Re: Planning application WA/63/21/PL: Land East of Tye Lane, Walberton.

Walberton Parish Council wishes to register an **objection** to this application. We have the following concerns.

VIEWPORT 1 - PROPOSED RESIDENTIAL ACCESS AT TYE LANE

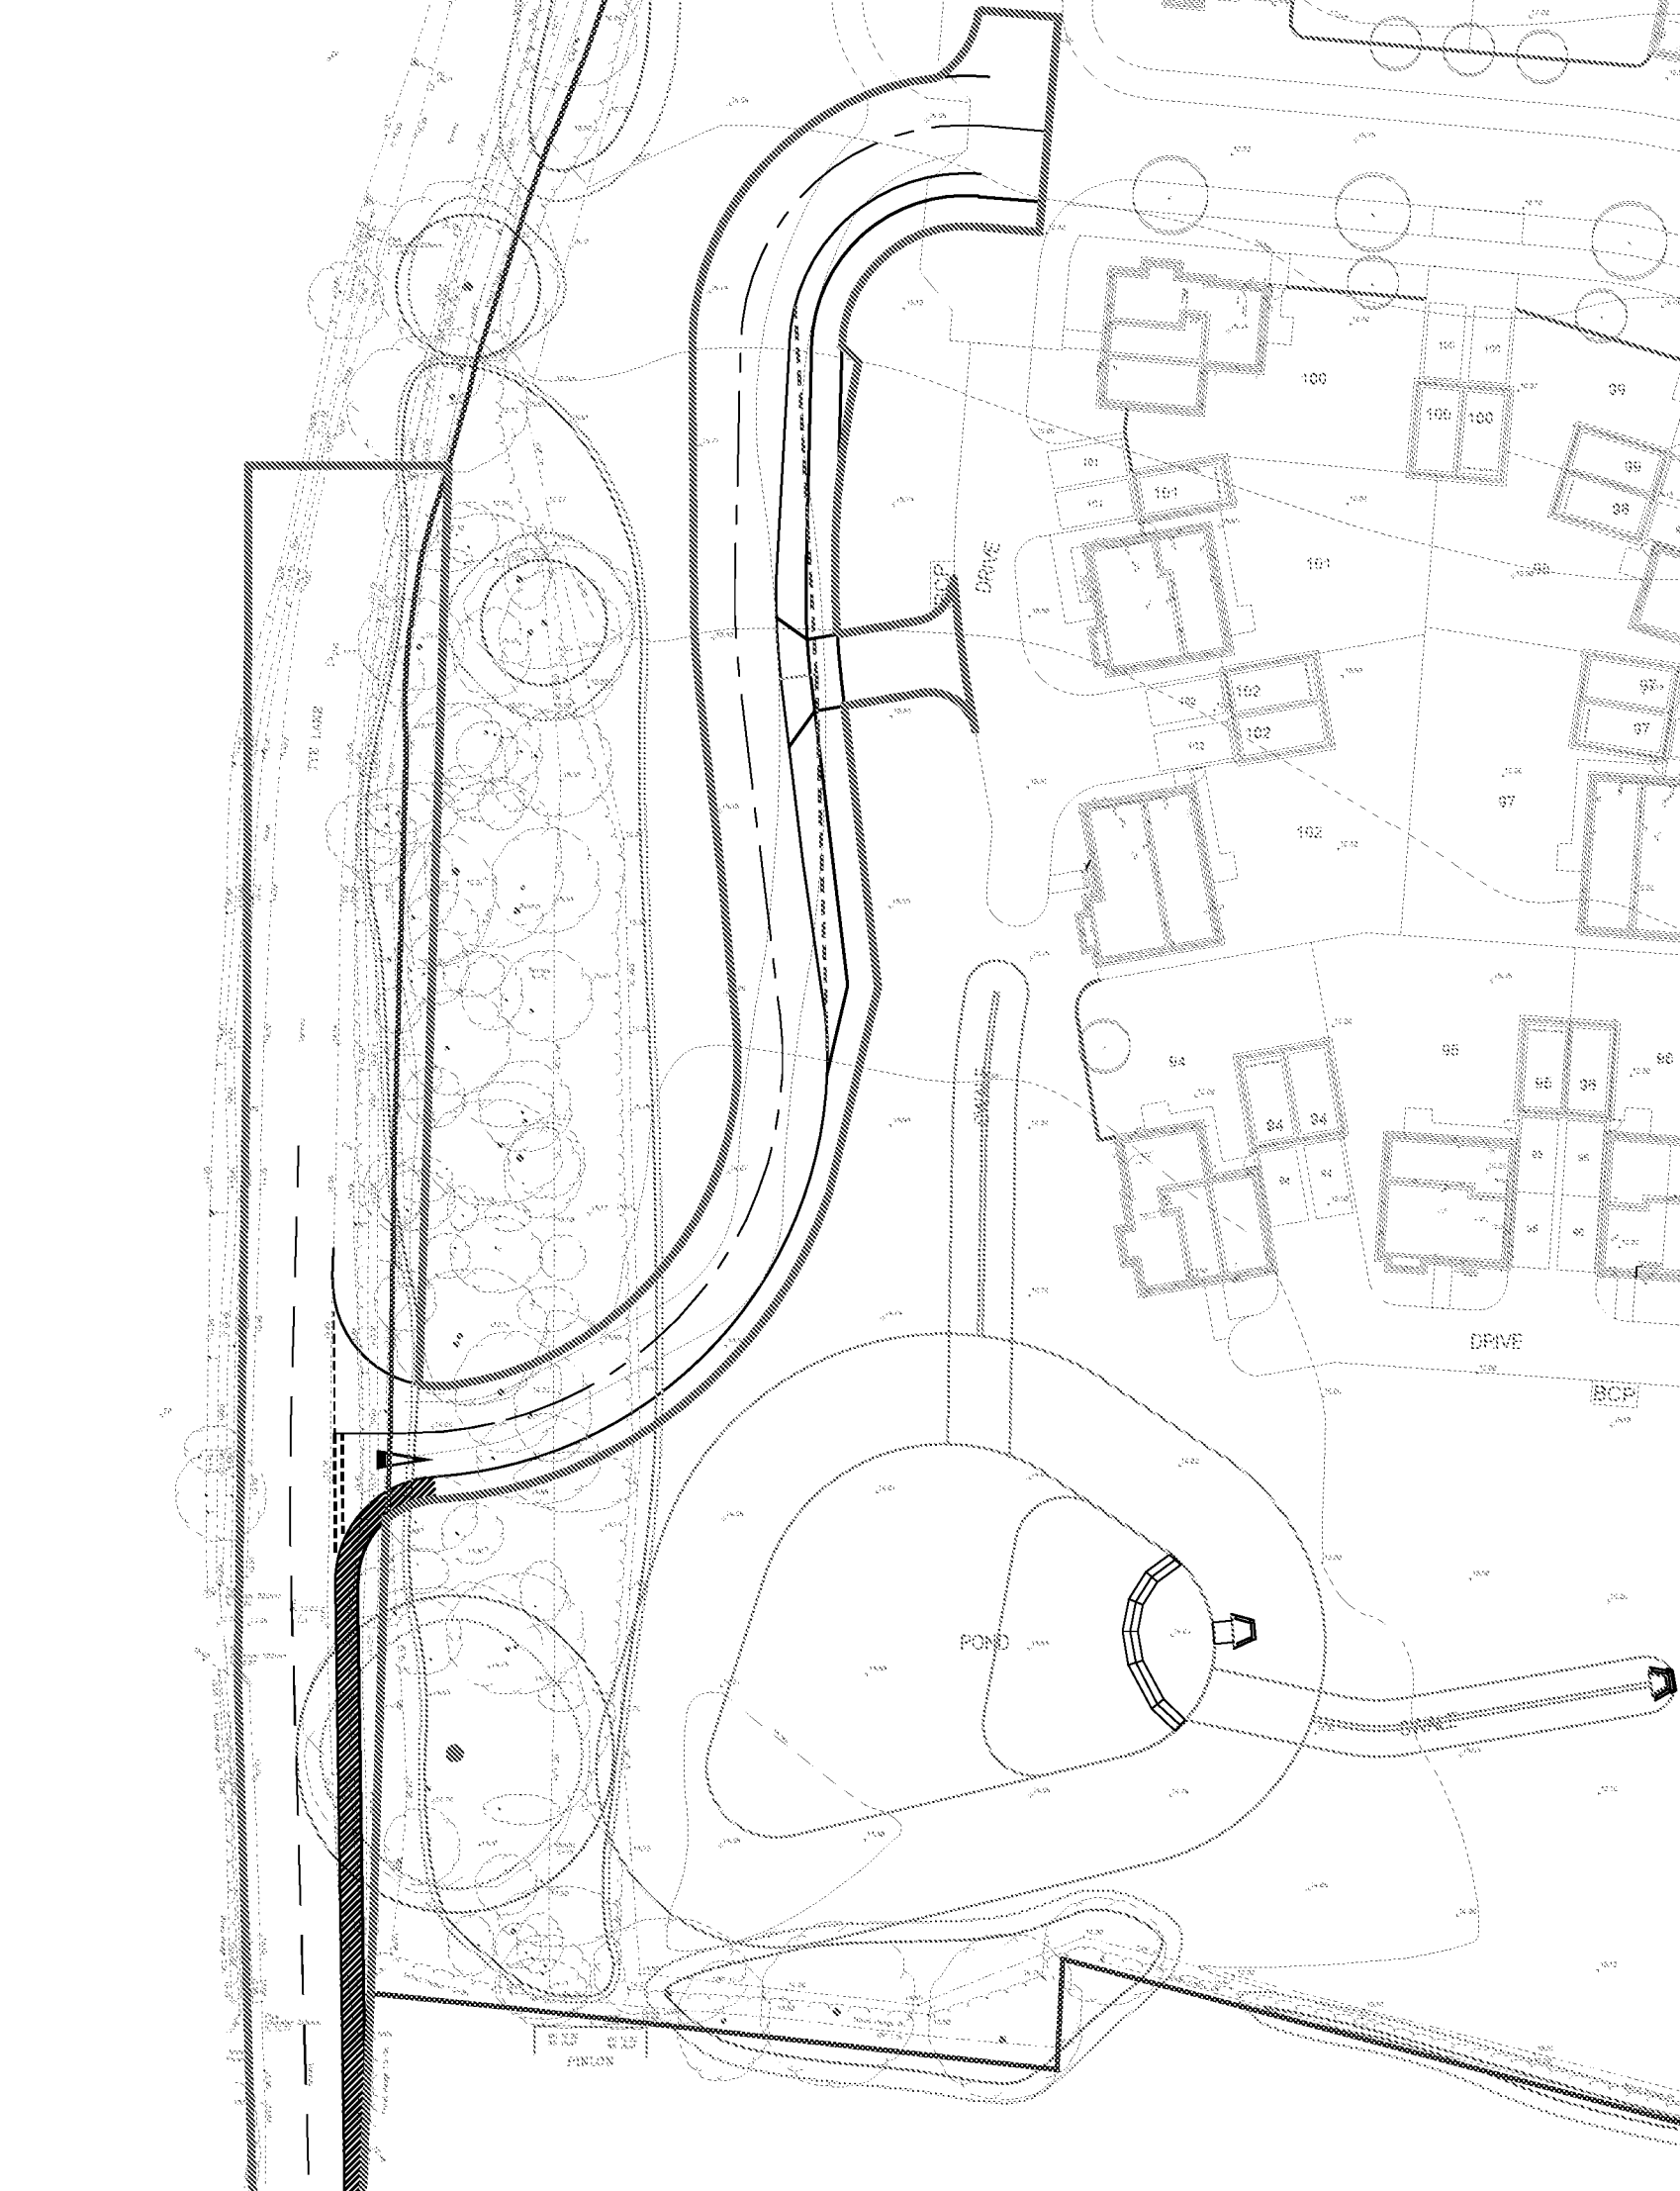
Tye Lane is significantly narrower than Yapton Lane for vehicle movements. The new application reduces Tye Lane to a minimum of 4.8m rather than 5.0m for approximately 25m. This would mean that an HGV and a car could no longer pass at this point (there is zero clearance for such vehicles). The application would provide that two vans (2.4m wide) would be able to pass with zero clearance between both the vans and kerbs. This will encourage vehicles to mount the pavement, posing a risk to pedestrians. This is a real problem for the frequent traffic from Hooe Farm Industrial Estate, further compounded by Diamond Coaches using the site as their depot or storage location resulting in many large coach movements daily on Tye Lane. The values used for width in this interpretation are those listed as typical vehicle widths in the Manual for the Streets, published by the Department for Transport 2007, ISBN 978-0-7277-3501-0 p74. We note that they are greater than those listed by the developer in their drawings but critically include the width of wing mirrors. We also note that SUVs, an increasingly popular vehicle choice are wider than ‘typical’ cars of 14 years ago.

The proposed cycle route from Avisford Grange leads down this narrowed route. This will also pose increased risks to cyclists from traffic trying to pass them.

Our conclusion is that the reduced road width to accommodate the new access point poses increased dangers to pedestrians, cyclists and vehicular traffic on a road already suffering from its narrowed width.

VIEWPORT 2 - PROPOSED EMERGENCY ACCESS AT AVISFOD PARK ROAD

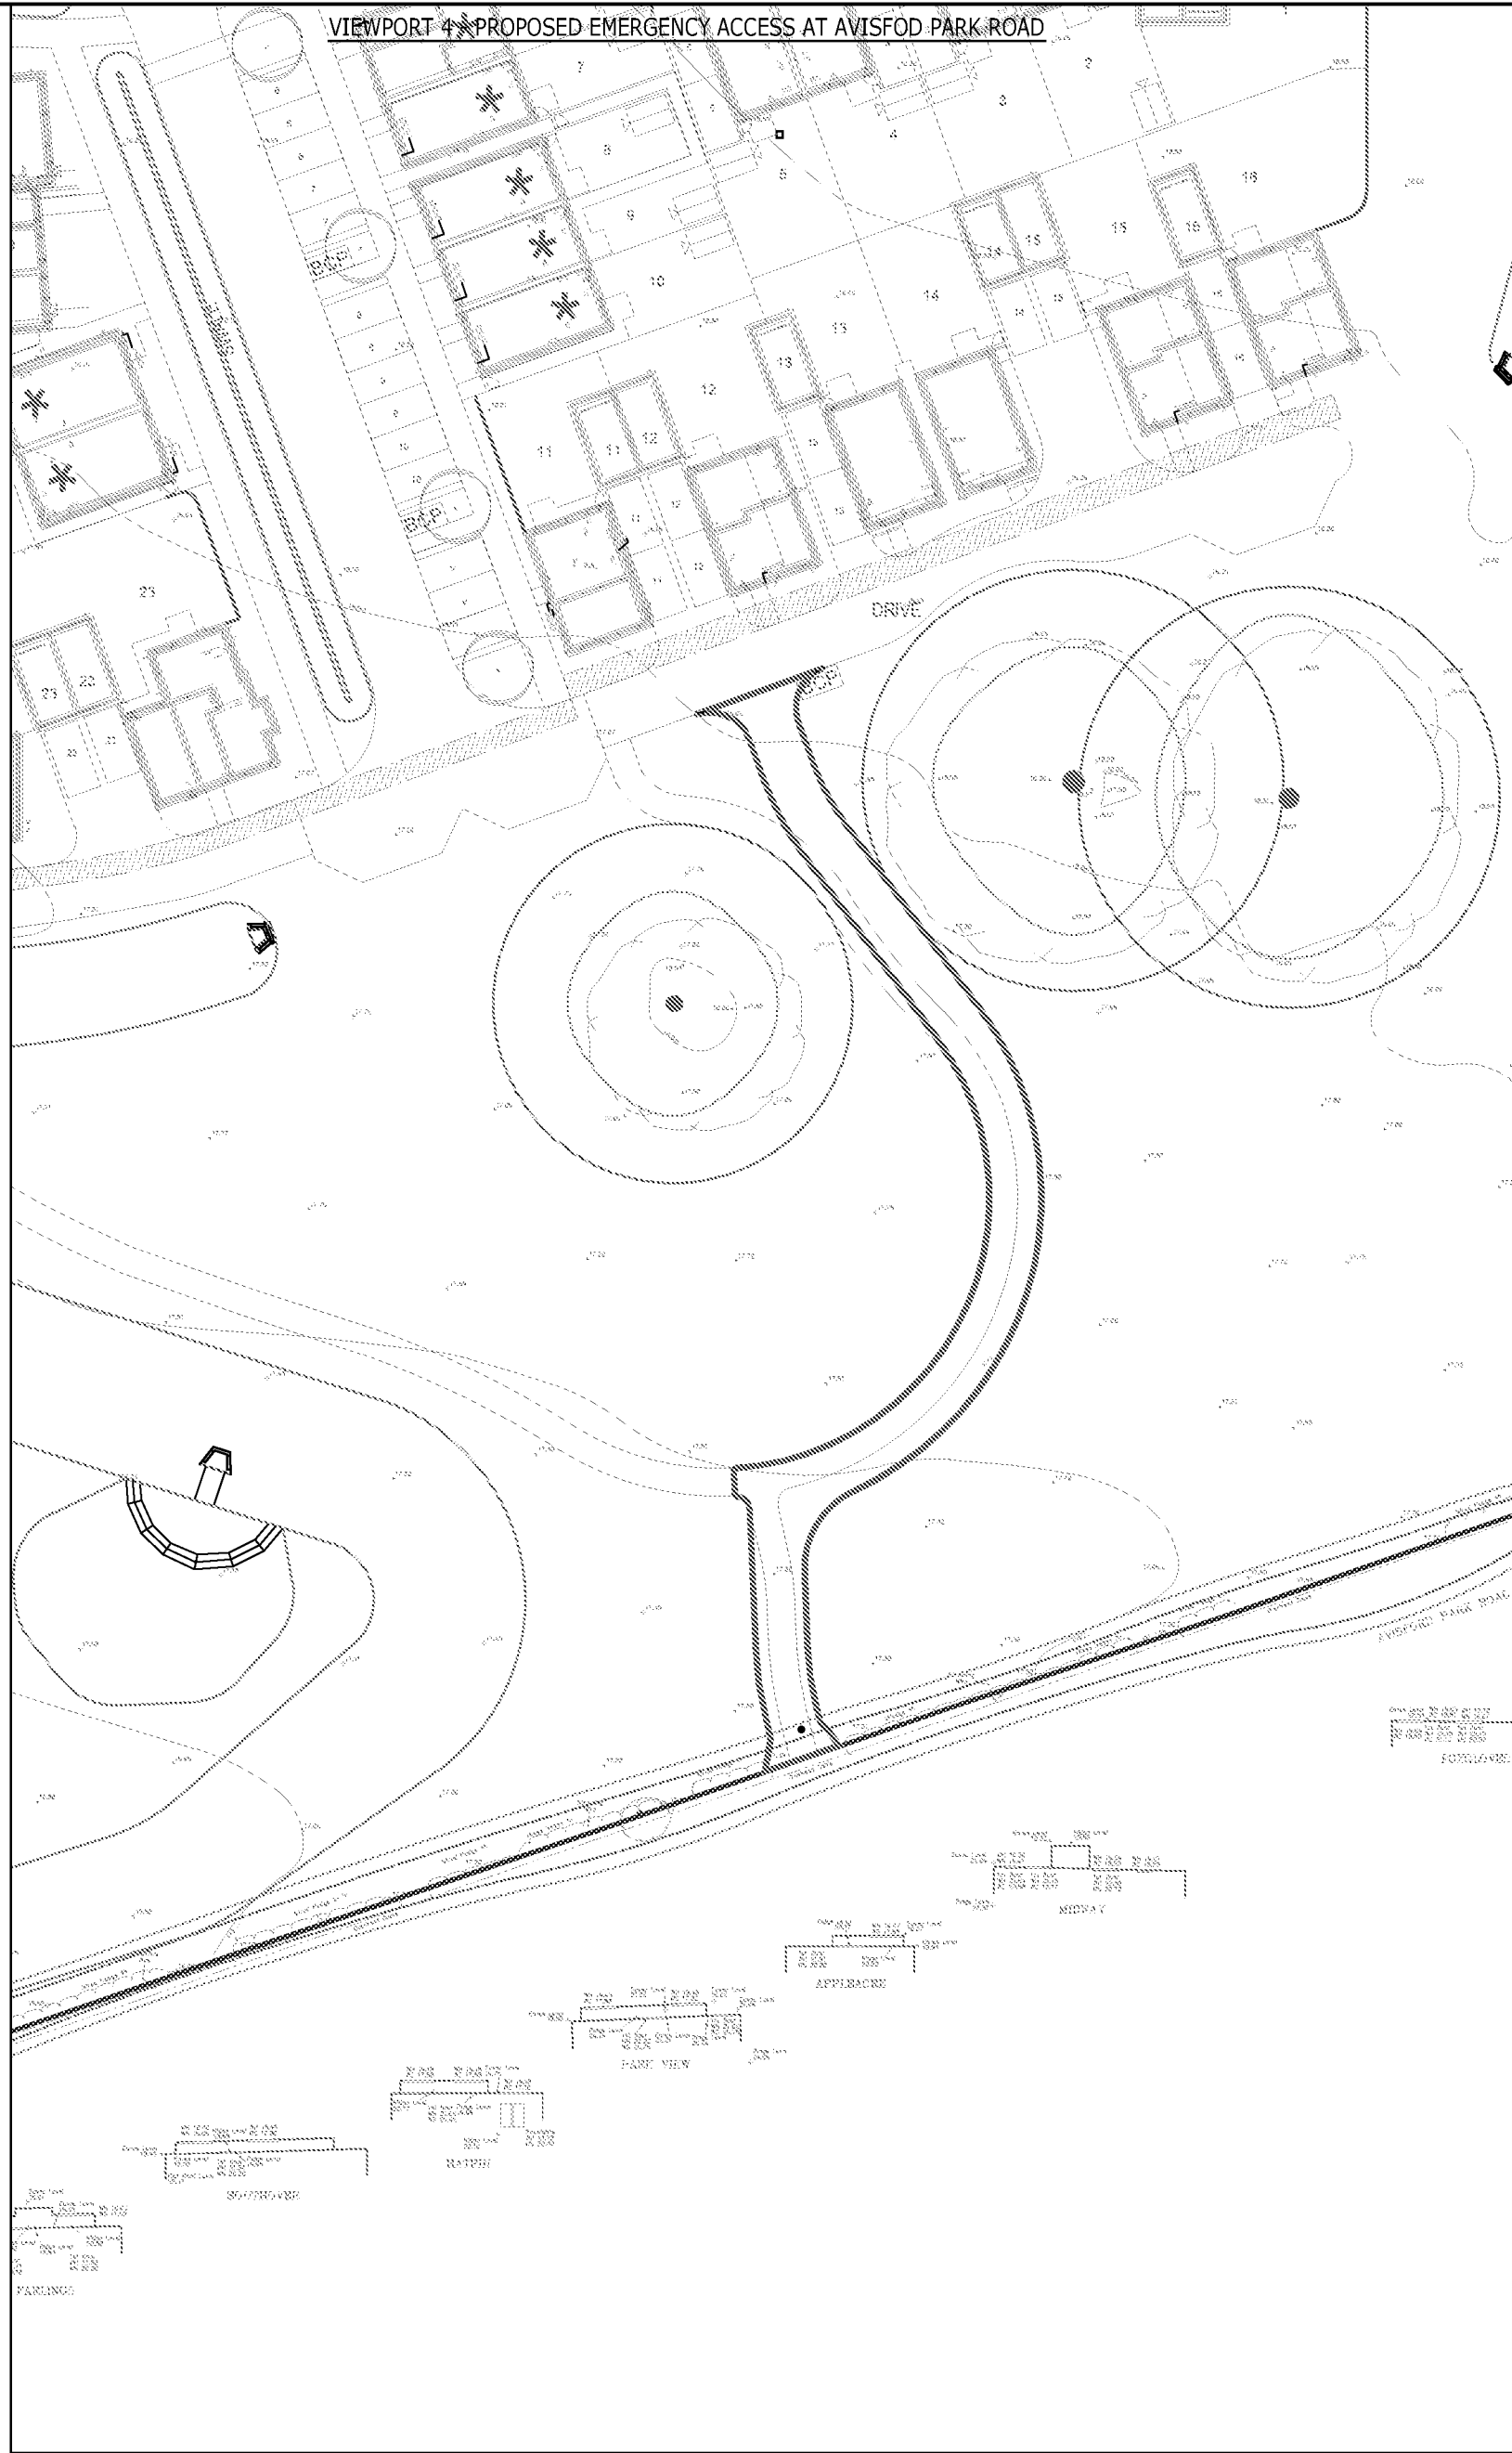
Emergency access (including access for fire appliances) is considered wholly inappropriate onto this narrow unsurfaced and unadopted road. We will await with interest the consultation response on the application of West Sussex Fire and Rescue Service. The application shows 2-way access. The shown left turn into AG is not possible as Avisford Park Road is only accessible by vehicles from the Yapton Lane end. Therefore, only a right turn is possible. The widened path proposed for emergency vehicles is in the public open space and the applicant has not made clear how this will impinge on this space, particularly as regards the safety of users.

The developer considers APR suitable because of its use by the Council's refuse vehicles; whilst concurrently noting that the refuse vehicles reverse down the road in order to drive back out.

APR is wide enough for a single vehicle only: two vehicles cannot pass each other. It is frequently blocked by parked cars and delivery vehicles, and is used once a year for a community street event. The developer has no legal right of access onto Avisford Park Road, as disclosed in the Land Registry title for Tupper's Field, now the Avisford Grange development. The developer is therefore not able to deliver this emergency access at the present time and it should be discounted, or delivery of the access should be made the subject of a Grampian condition prior to commencement of development of the Tye Lane access (should permission be granted).
